RE: Indaver Ringaskiddy_ ACP planning application 318802.
Your ref: Land area measurement included in Application.

Dear Joe,
Attached please find Map 1, Map 2, Map 3, Map 4 and Map 5.
Plot on A3 sheets for clarity.

**Map 5 OSI mapgenie 25 inch (1897 to 1913)**  
 Scale 1:2000 on A3 sheet  
 Prepared by Con Sheehan, Land surveyor FCSI  
 on 5th November 2025

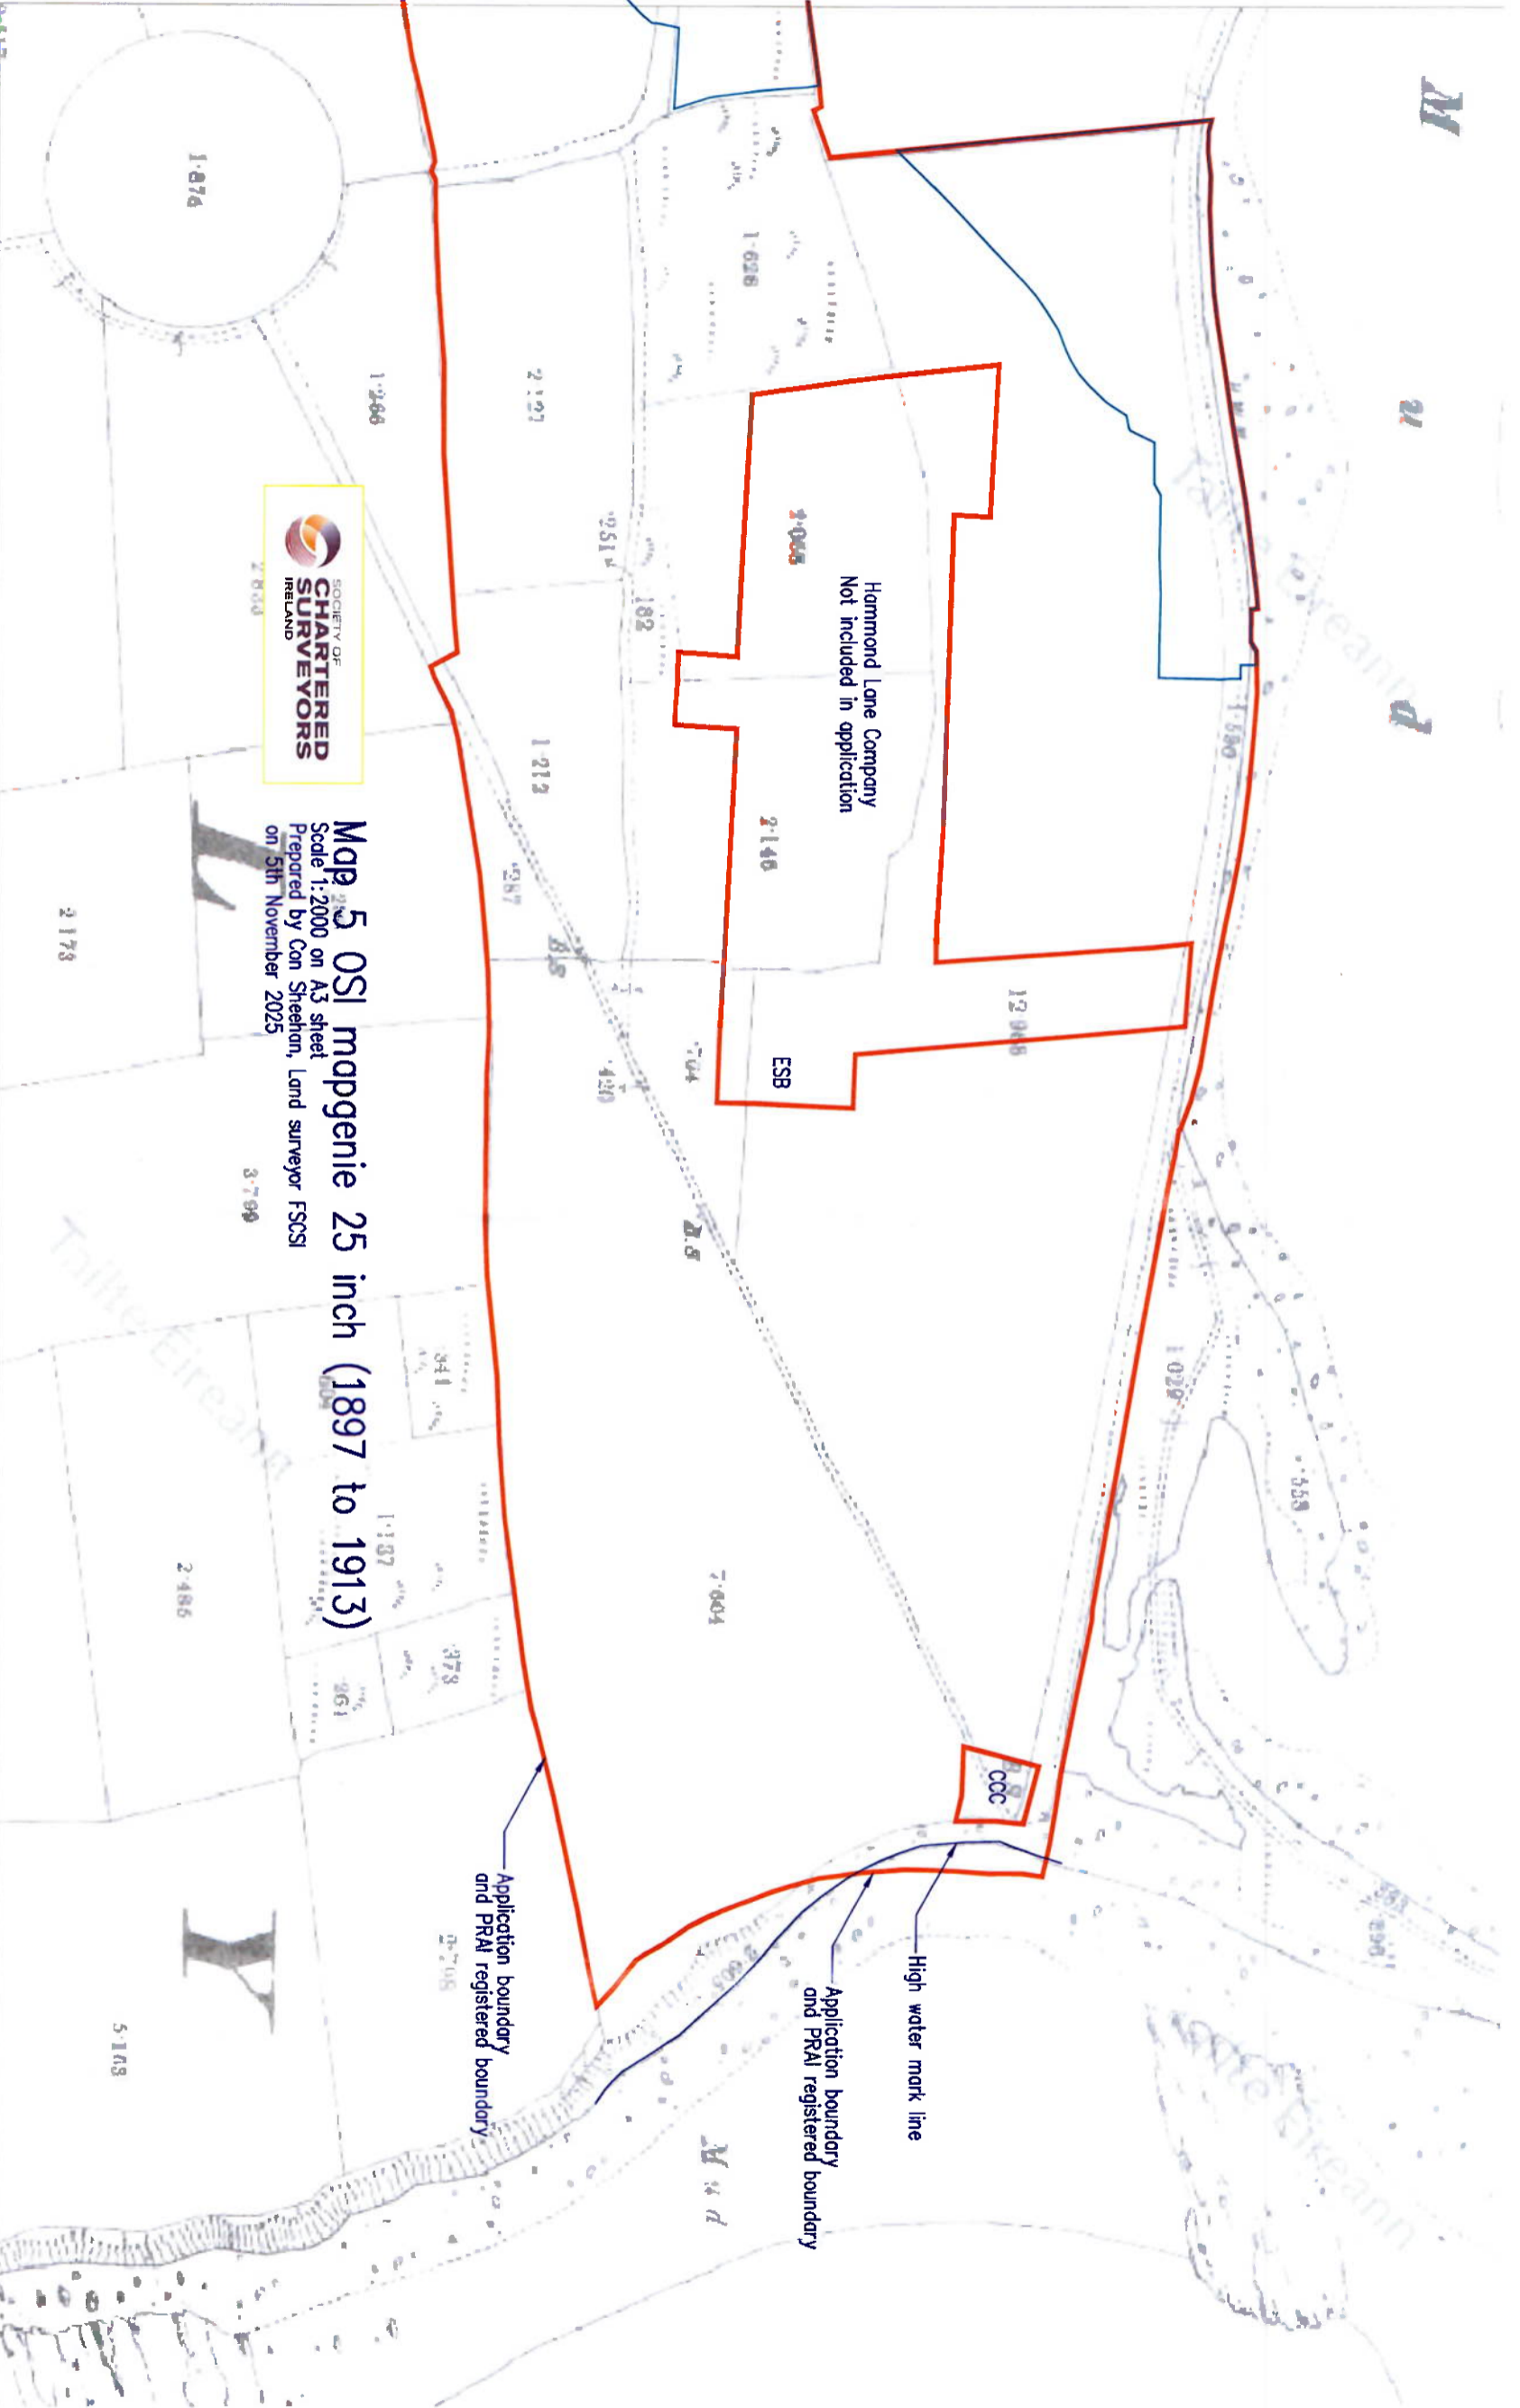
Map 5 is another Ordnance Survey map background which shows the same high water mark. The legal boundary line at the foreshore would need investigation.
